STATE OF WASHINGTON
DEPARTMENT OF ECOLOGY
1250 W Alder St • Union Gap, WA 98903-0009 • (509) 575-2490

Re: SP-15-00010

Thank you for the opportunity to comment on the short subdivision of approximately 59.7 acres into 3 lots, proposed by Joan Nelson. We have reviewed the application and have the following comments.

Critical Areas  
Map

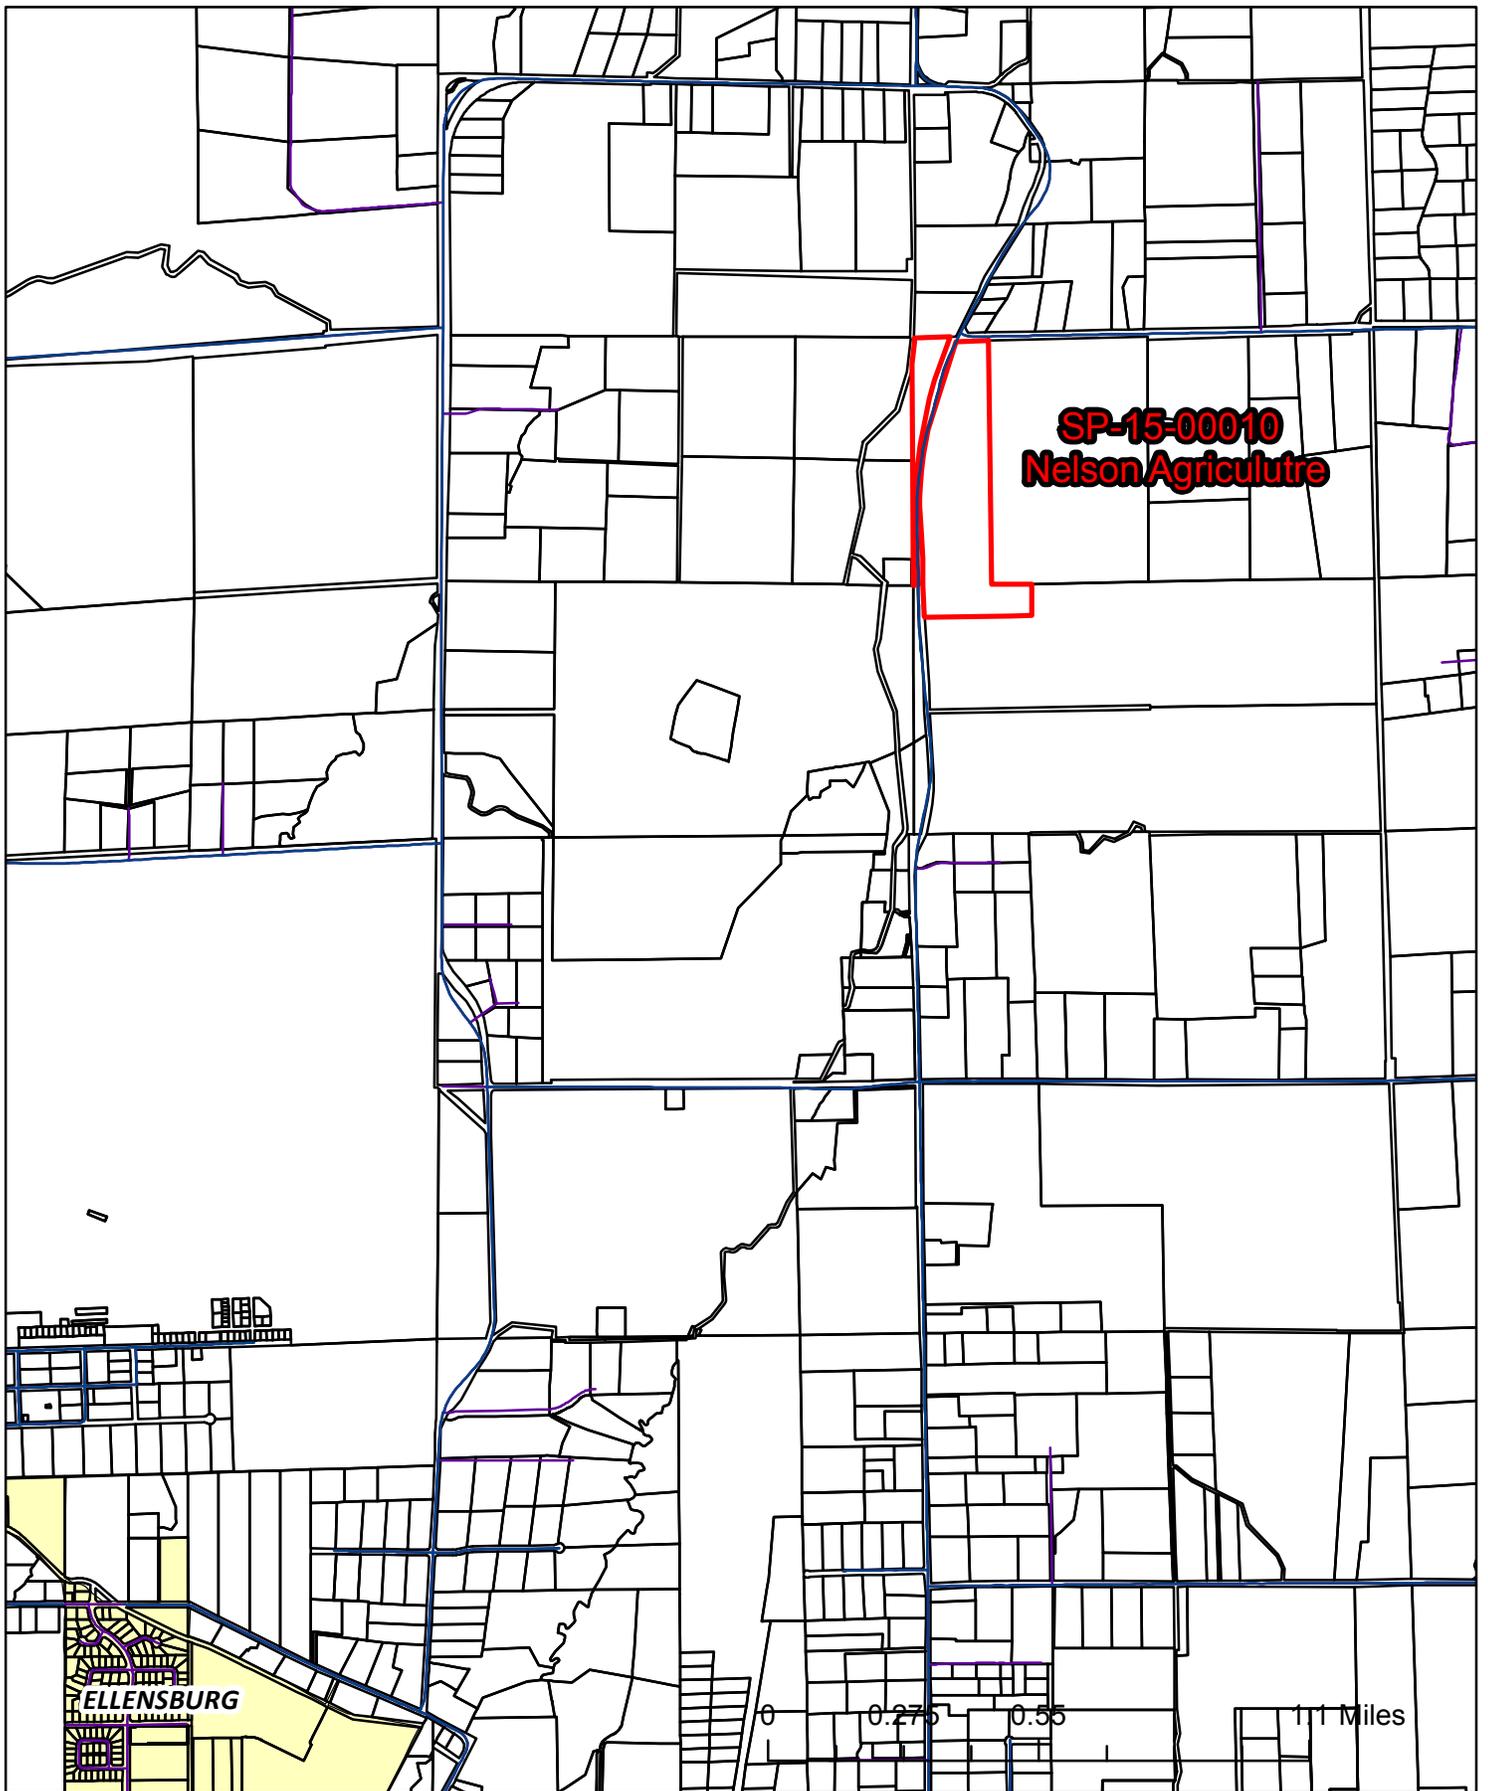
It appears as though the 6.38 acre lot (not part of this subdivision?) on the west side of Wilson Creek Road may consist entirely of a riparian wetland area or its buffer. Lots which are unbuildable should not be created, unless they are purposefully set aside as open space and designated as unbuildable. The creation of new fields or agricultural activities within wetlands may trigger state and federal permit requirements before activities are begun.

If development will be proposed for lot 2, a wetland delineation should be completed to assure that placement of new building envelopes and new access roads will not occur within critical areas or their buffers. Lots should be designed which do not require intrusion into wetland areas or their required buffers zones for access or infrastructure (wells and utilities, etc.) and buildings. The National Wetland inventory maps may not show the full extent of wetlands or their exact location.

Waterways which drain or carry irrigation waters which were constructed within hydric soils (wetlands) may also be of concern to state and federal authorities and work within them may require permits. This parcel and adjacent parcels has been so altered by ditching that it is not clear where floodwaters flow or where the main Wilson Creek channel is located.

Below is a map with some potential wetland areas (outlined in yellow) and streams (shown with a blue line) that are not identified on the NWI maps. There may be other areas of concern on site as well. For instance, there is a linear area in lot 2 through which flood flows may travel which could meet the requirements to be designated a stream or wetland. Any impacts to wetlands should be mitigated.
